RE: Fire District 6 Public Facilities Application (PF-14-00001)

MEMORANDUM

TO: Kaycee Hathaway, CDS
FROM: Christina Wollman, Planner III *CW*
DATE: April 25, 2014
SUBJECT: Kittitas County Fire District #6 PF-14-00001

GRADING PLAN
 KITTITAS FIRE PROTECTION DISTRICT #6
 RONALD, WASHINGTON

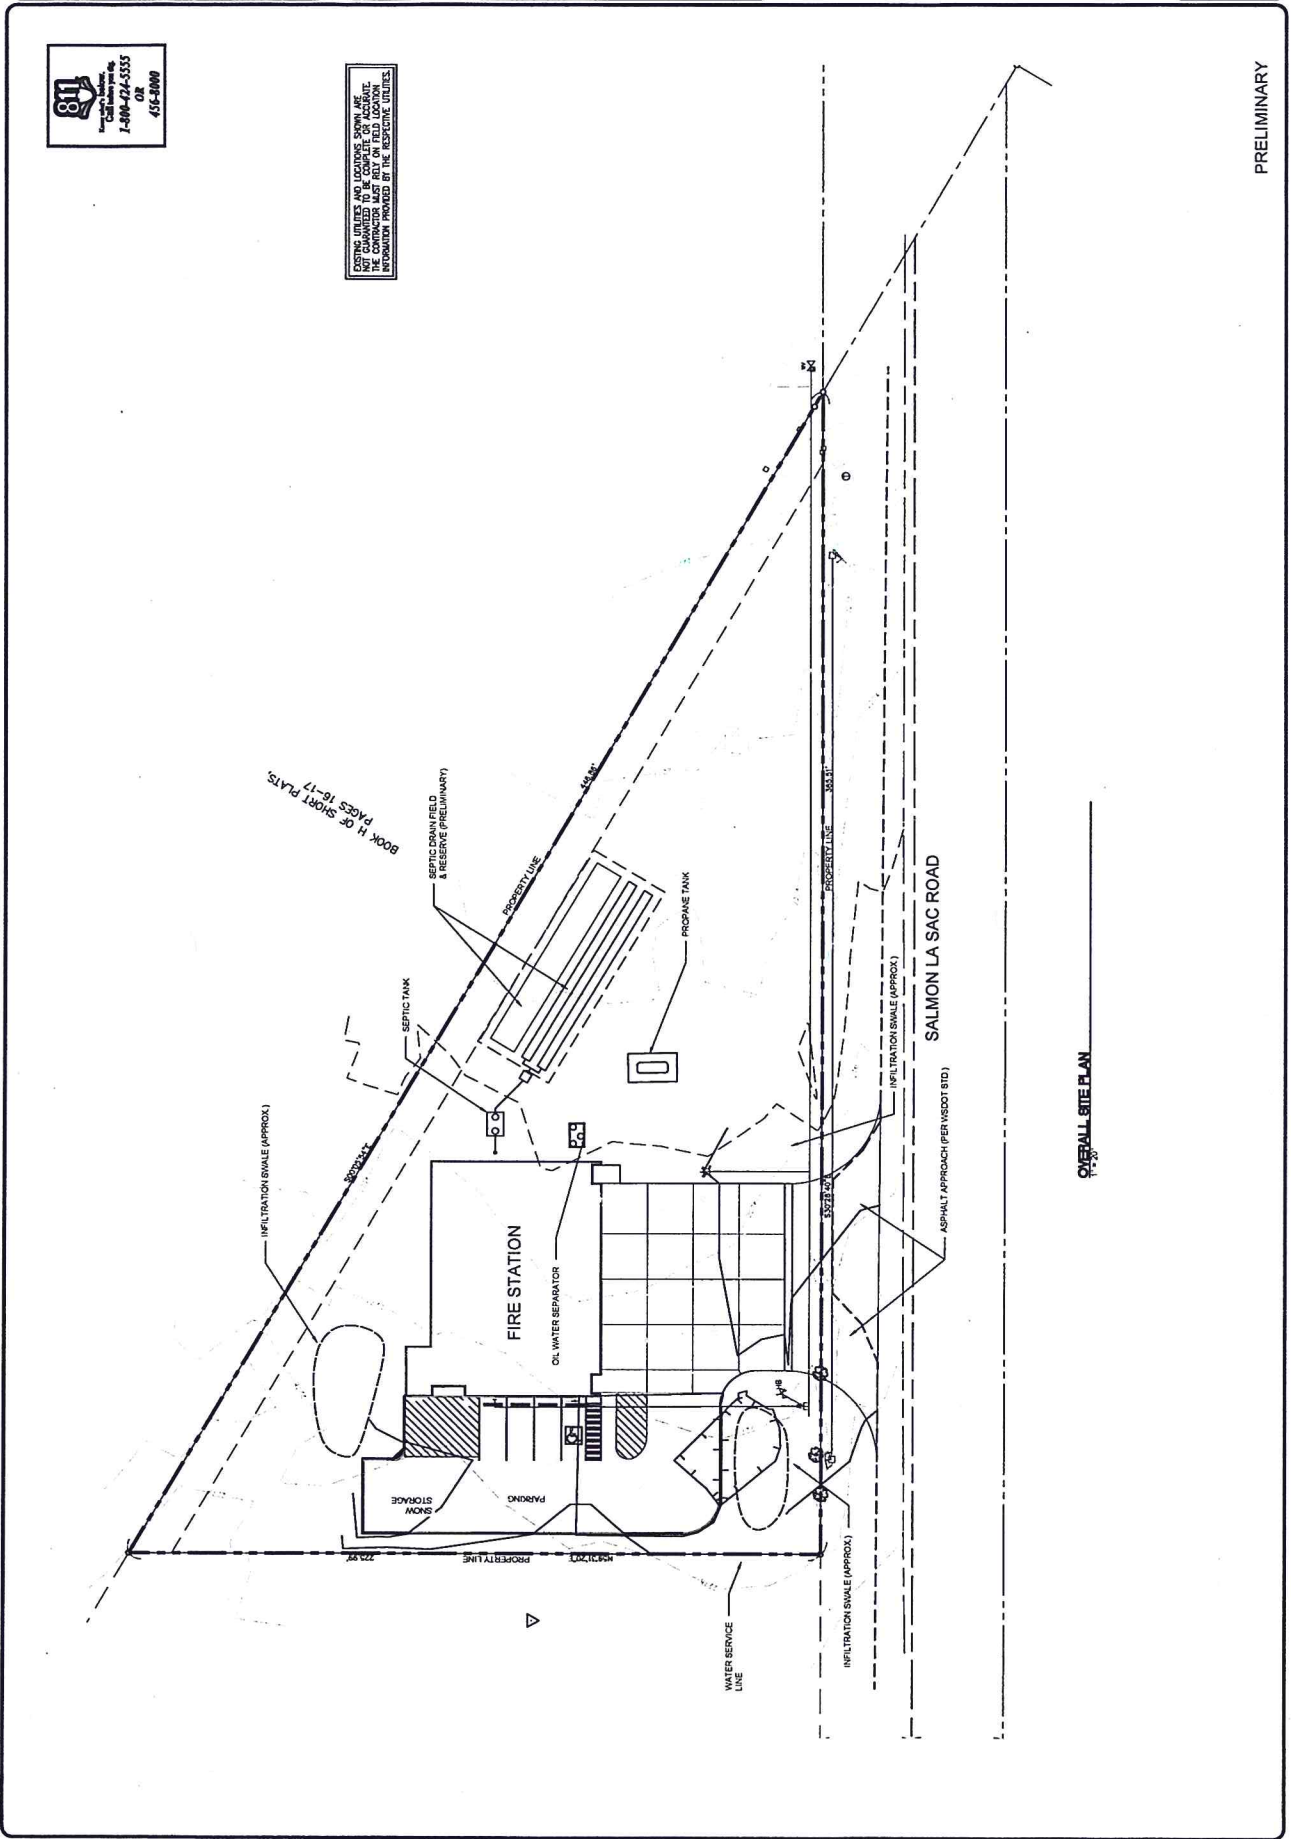
- B. Stormwater: On-site stormwater management that conforms to the specifications of the most current version of the Stormwater Management Manual for Eastern Washington is required of this development. Stormwater systems shall be designed to store stormwater generated by a 24-hour, 25-year storm event. Stormwater system designs shall be prepared and stamped by a civil engineer licensed in the State of Washington. The stormwater system design shall be presented to Public Works and reviewed by the County Engineer prior to issuance of a building permit. The stormwater system construction shall be certified by a licensed engineer prior to issuance of an occupancy permit.

OVERALL SITE PLAN

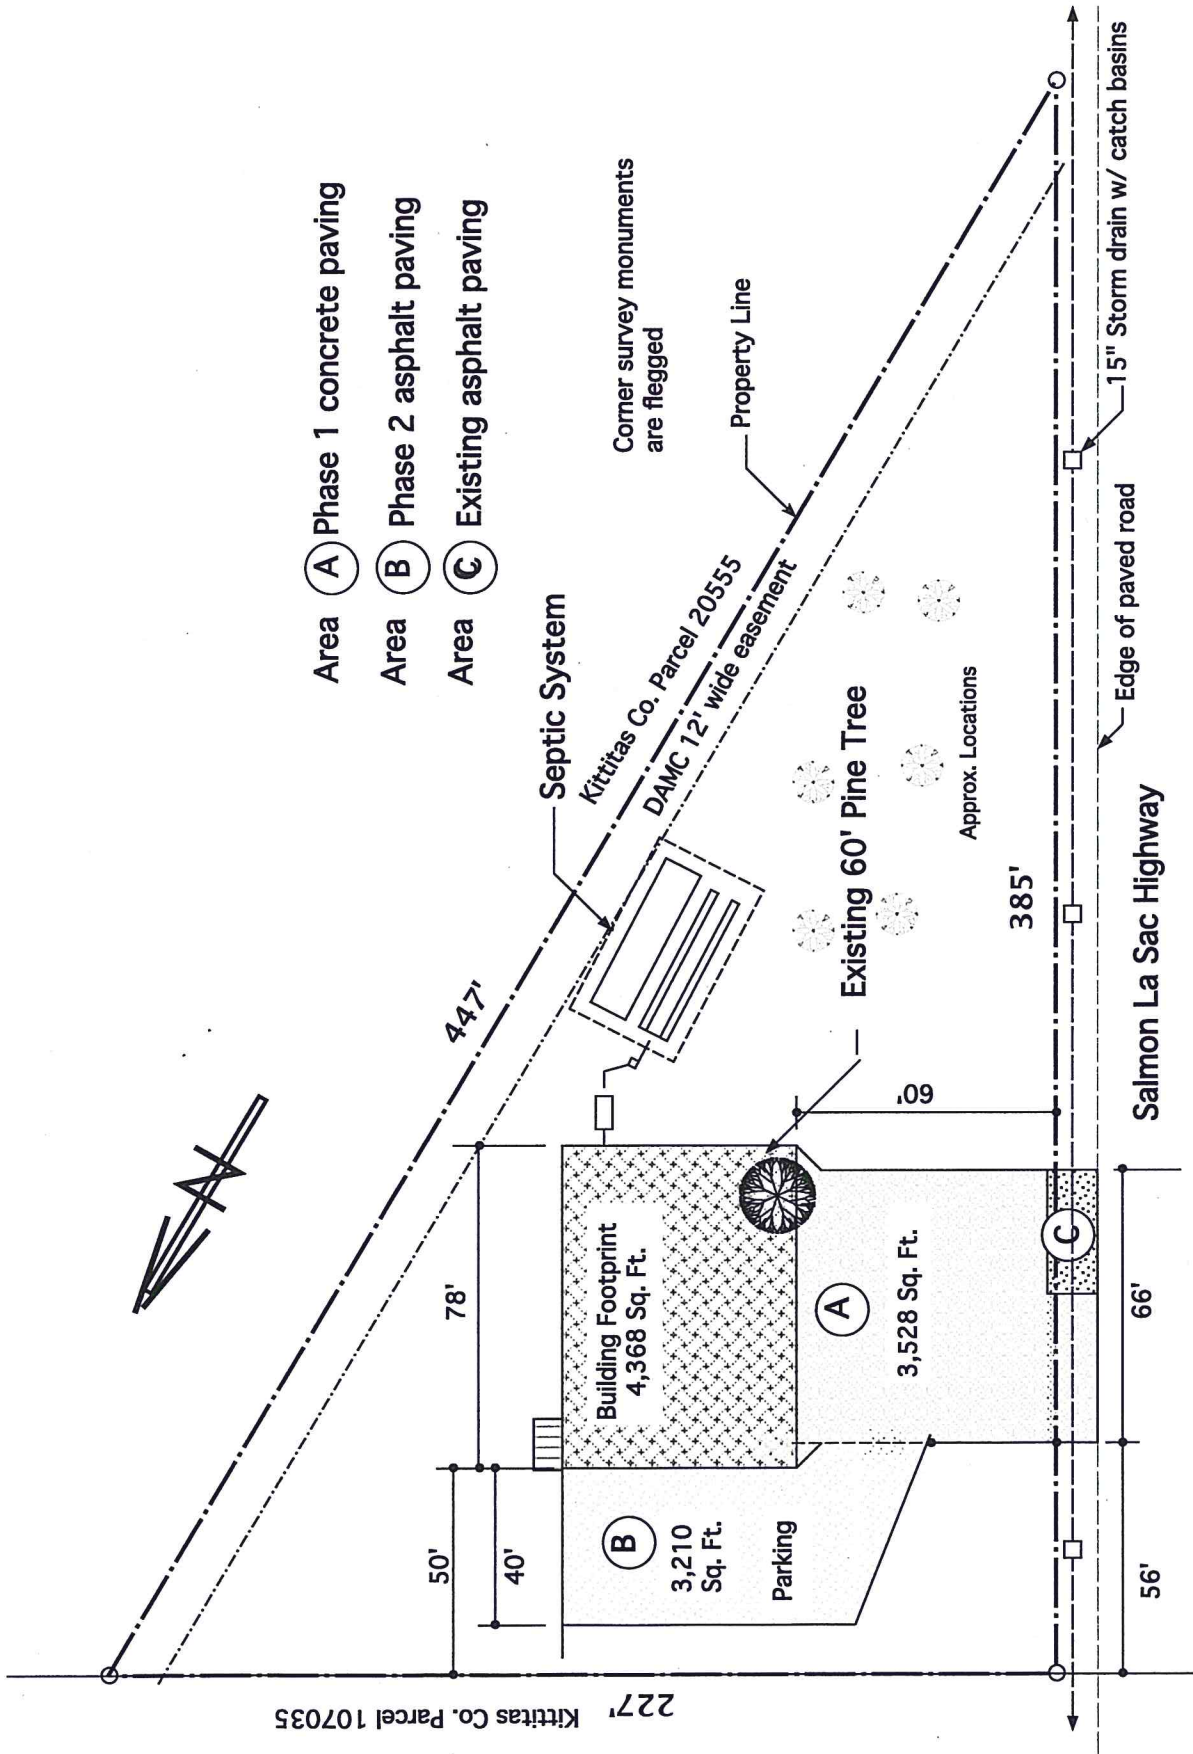
- A. Access: Access to the proposed Fire Station shall be constructed as required by Kittitas County Road Standards, which requires the access to be constructed to commercial standards. The access shall be constructed prior to issuance of an occupancy permit

- C. Access Permit: An approved access permit will be required from the Department of Public Works prior to creating any new driveway access or performing work within the county road right of way.
